From: Amanda Scholes on behalf of Planning.Responses
Sent: 11 March 2021 08:47
To: Planning Scanning
Subject: FW: : PLANNING PERMISSION EP/16/21/PL

Planning Permission

Application No: EP/16/21/PL
Registered: 3rd February 2021
Site Address: Land East of 1 The Way East Preston BN16 1QJ
Grid Reference: 507488 101707
Description of Works: Replacement garage. This site is in CIL Zone 4 (Zero Rated) as other development.

Client: Mr D Lynch		
Project Address: The Garage The Way East Preston		
Drawing Title: Existing and Proposed Plans and Elevations		
Drawing Number: 1241.01.g		
Scale:	As stated printed @ A1	
Date:	06/01/2020

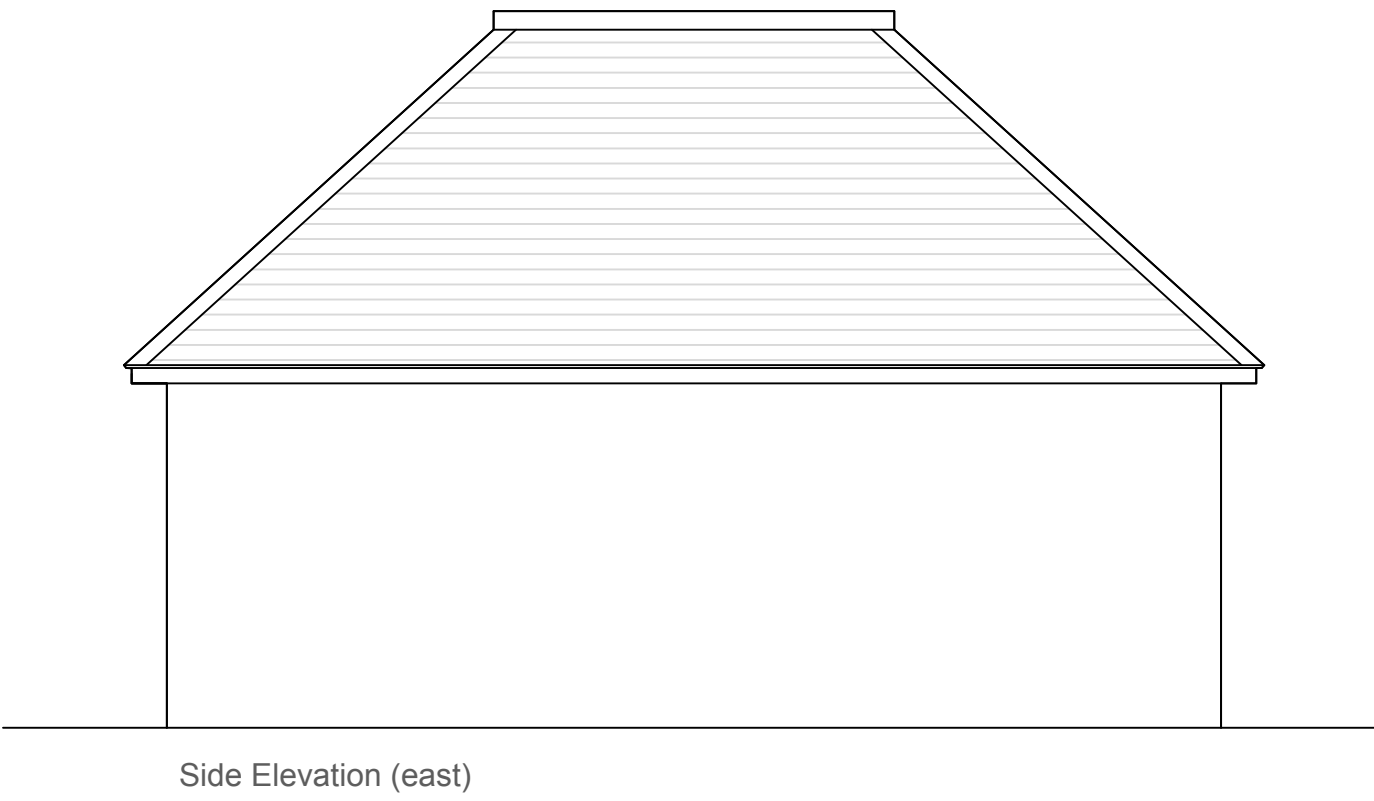
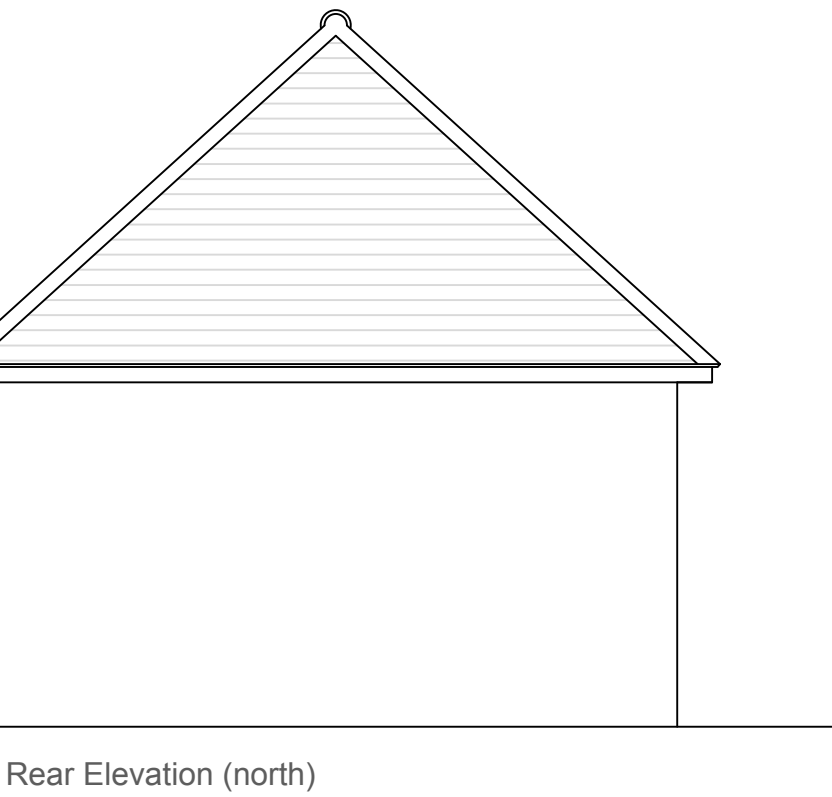
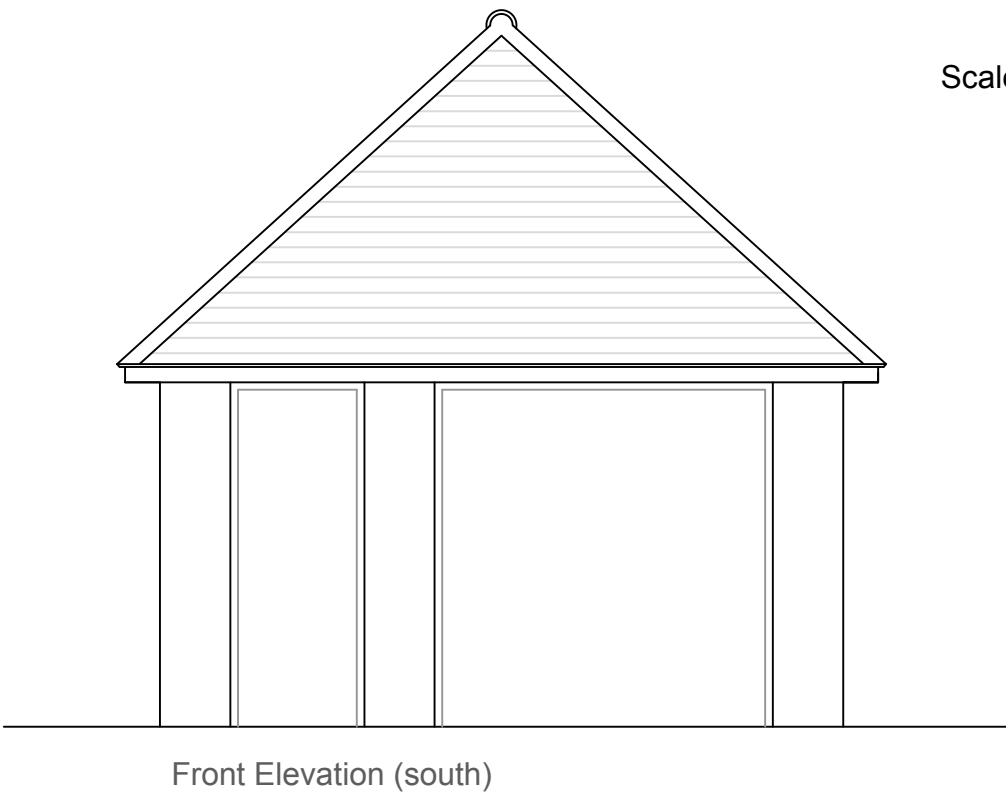
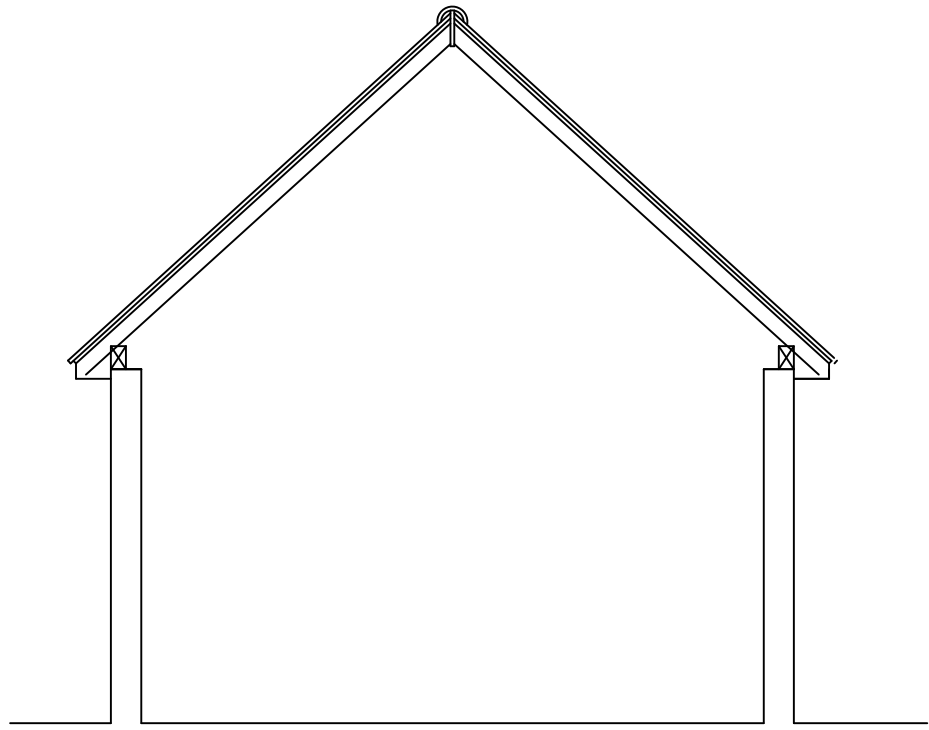
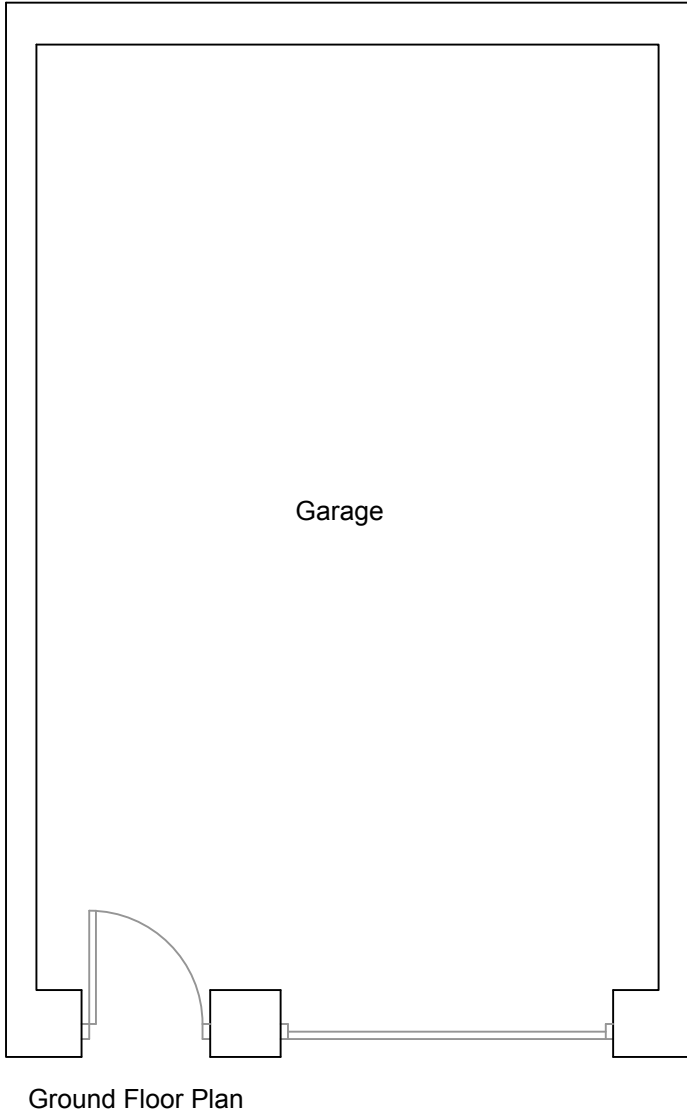
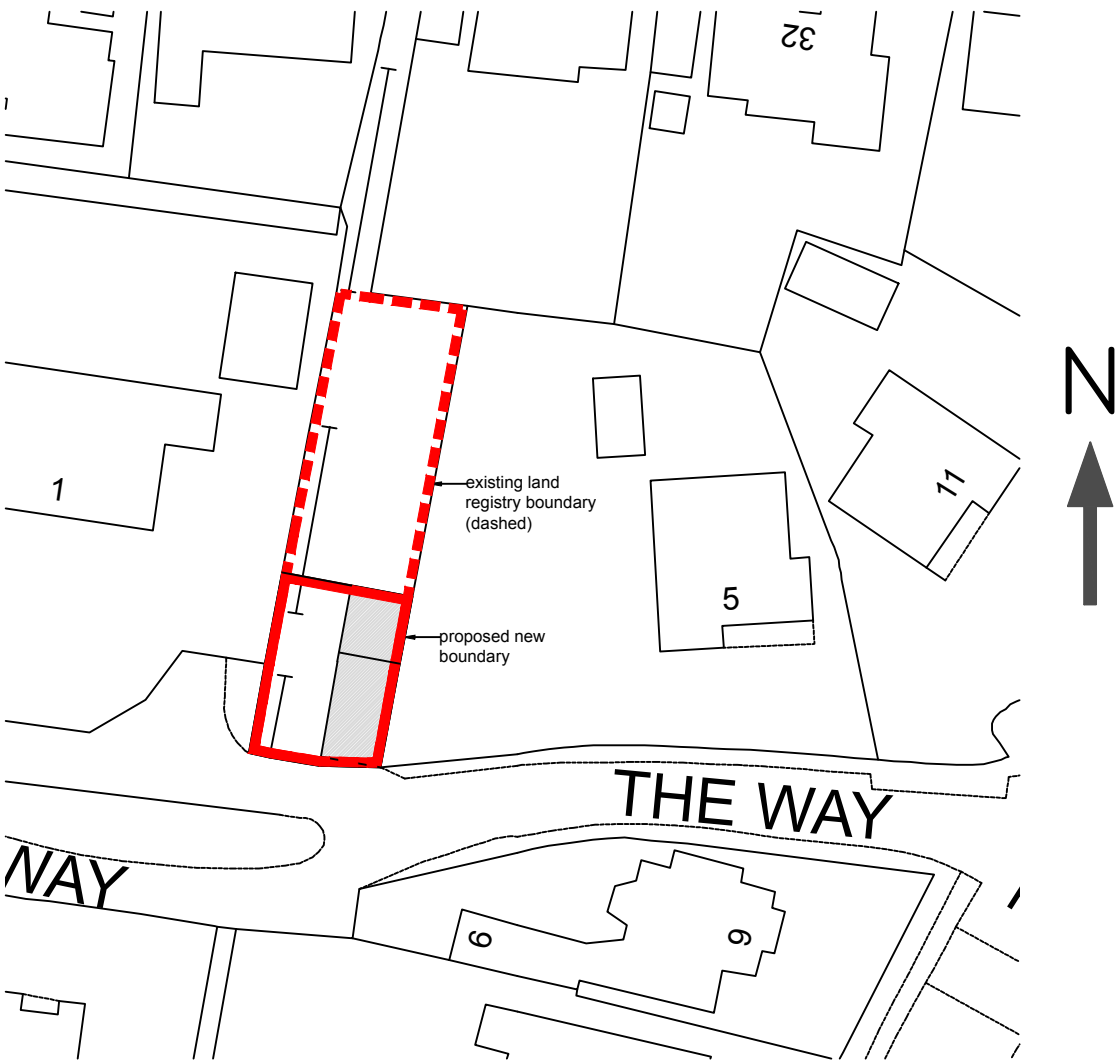
I note the above proposed plan seeks to build a new garage more or less where the existing garage has stood for a long time. I understand that the plans for the new garage will make it about three quarters of a metre taller and that the elevation on the South side will be vertical to the top rather than as a hip angled to the north and also that a window will now be included in the South elevation.

My objection to the plan is that The Way is a narrow road with an island in the middle portion and a vertical south elevation will be out of character with the rest of the properties on the Way which are set back from the curve. In addition with the window in the south elevation we will lose all of our privacy in the whole of our back garden which we have enjoyed for many years. We are not sure why a garage needs such a window and if it does then we would requested that opaque glass be a stipulation of the planning consent.
